PLAN REVIEW SHEET

Petition #: RZP 2022-176

Address: 348 Scaleybark Rd.

Request: TOD-NC (CD)

RZ1.00

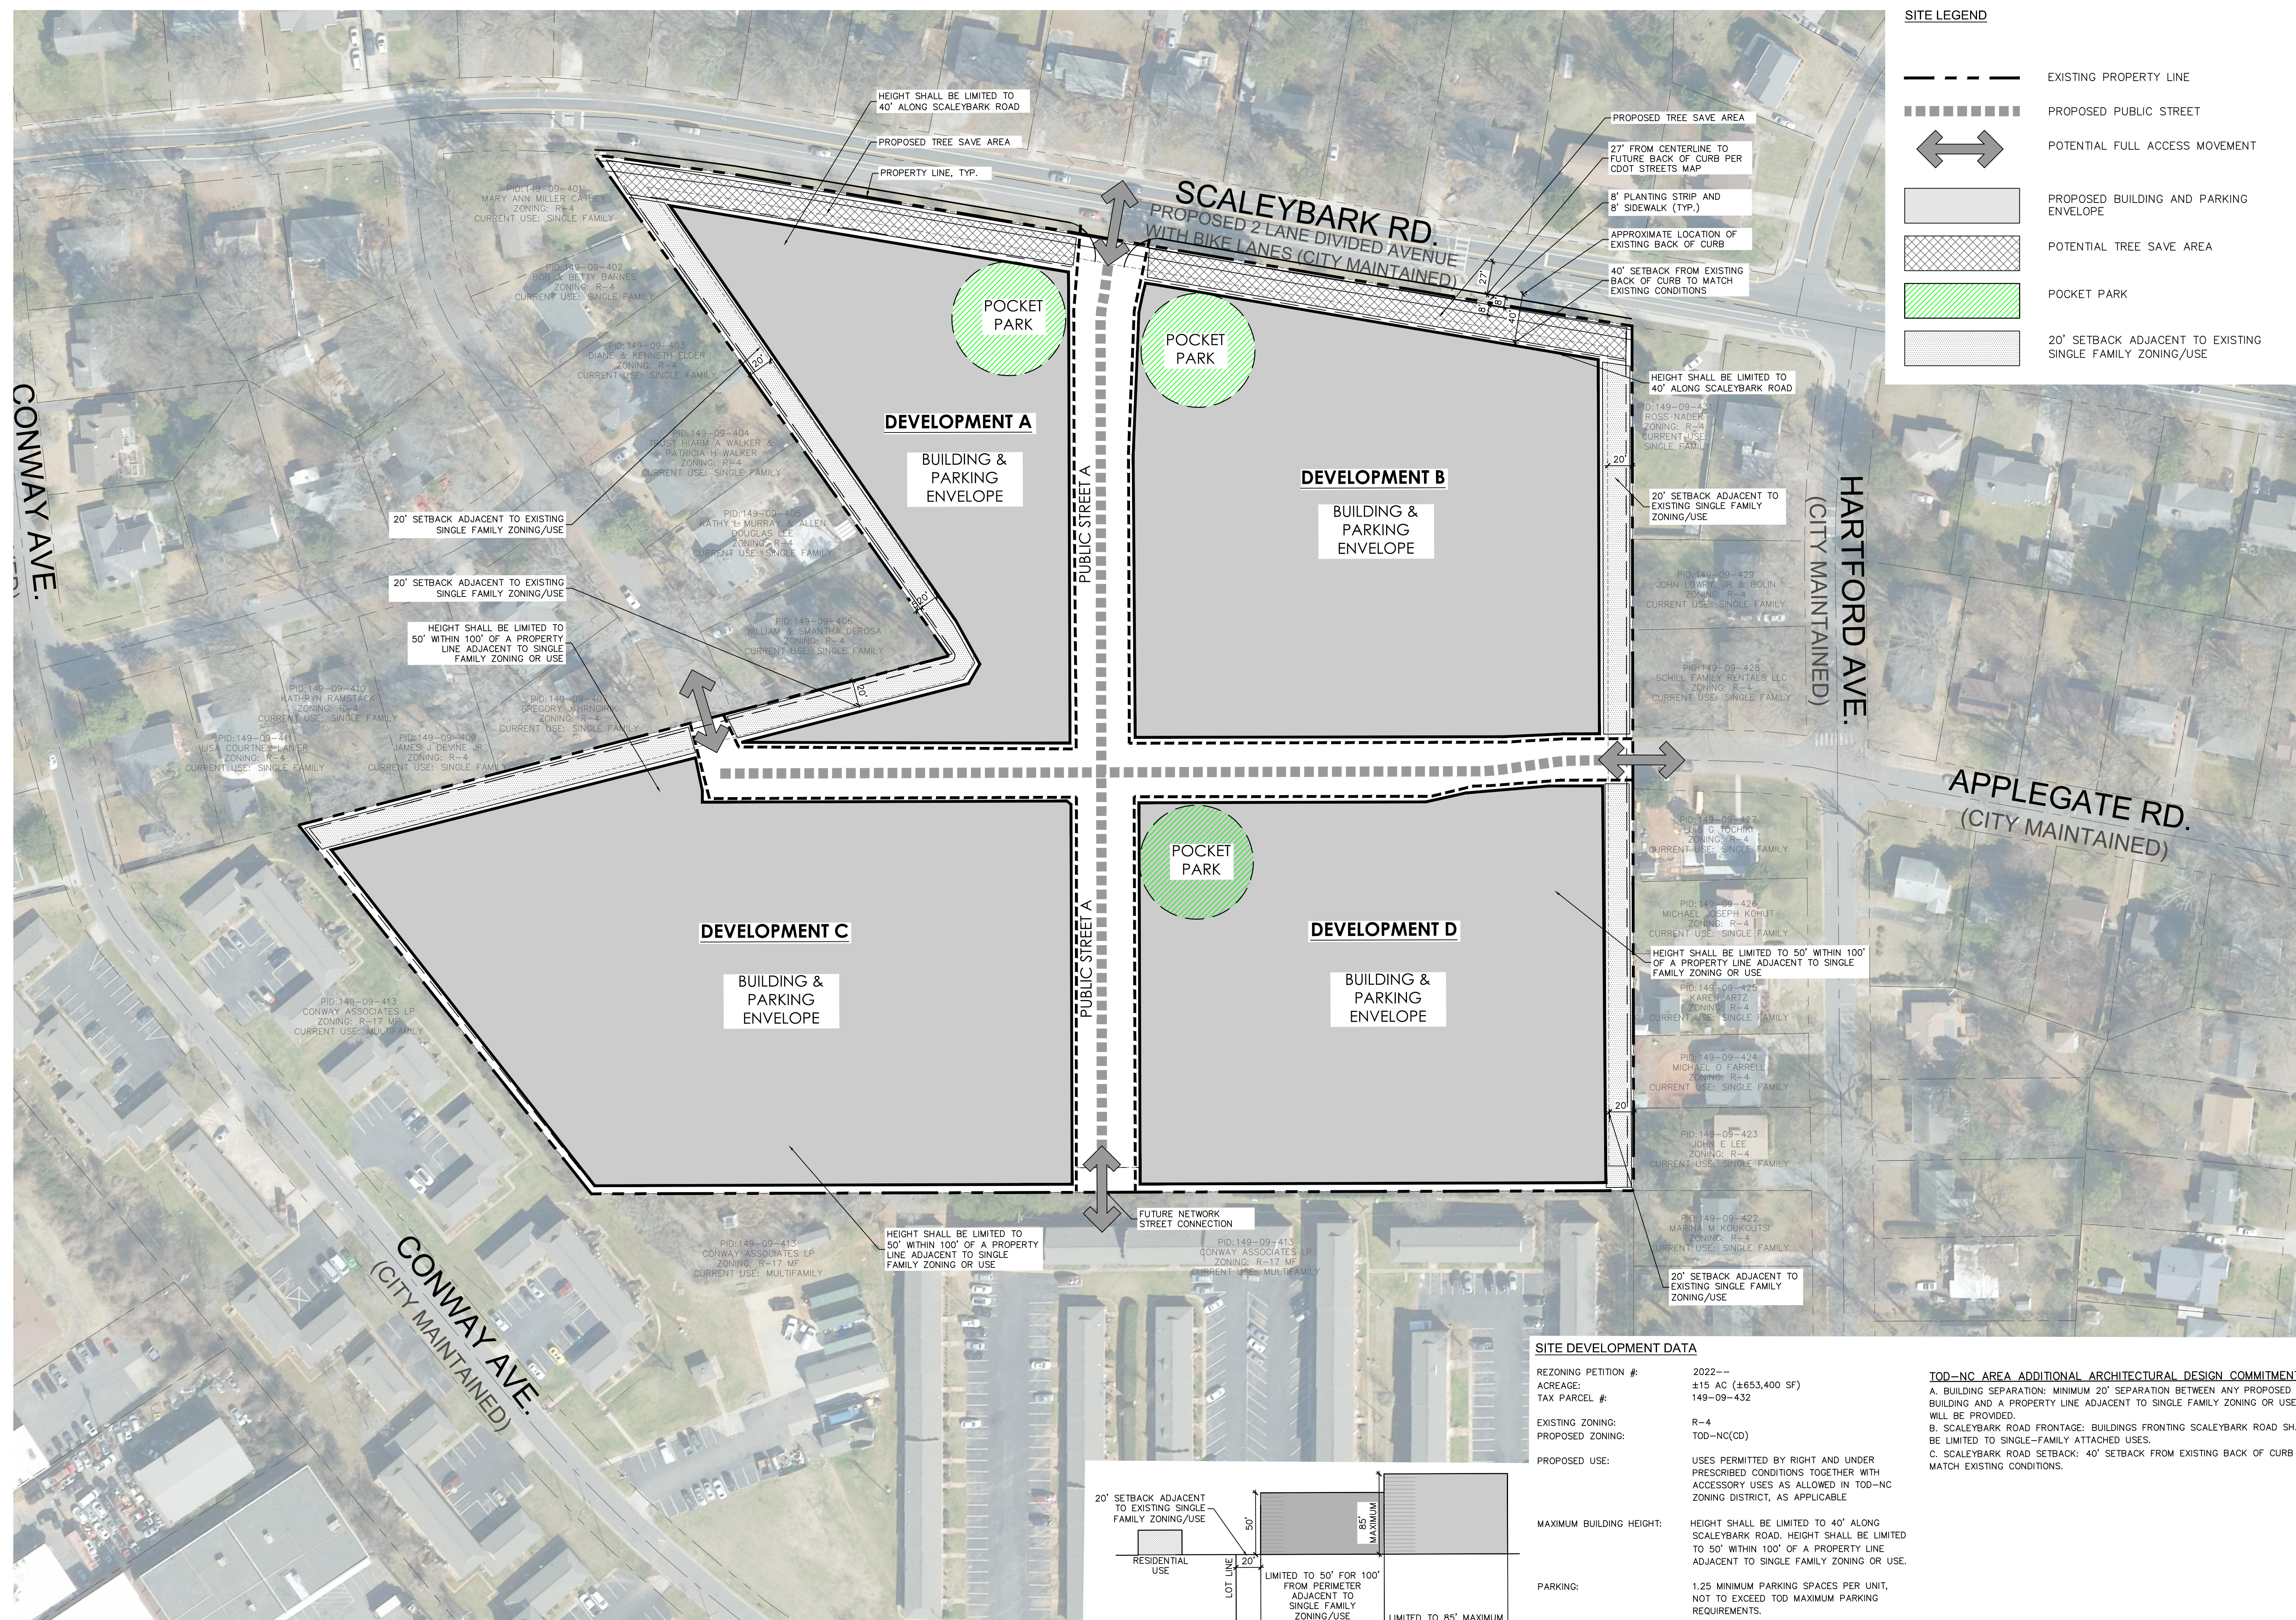
The site is located along CATS local bus route #30 on Scaleybark Road. CATS requests the construction of ADA compliant bus standard detail 60.03A on Scaleybark Road. The final location will be coordinated with the developer during the Land Development plan review process.
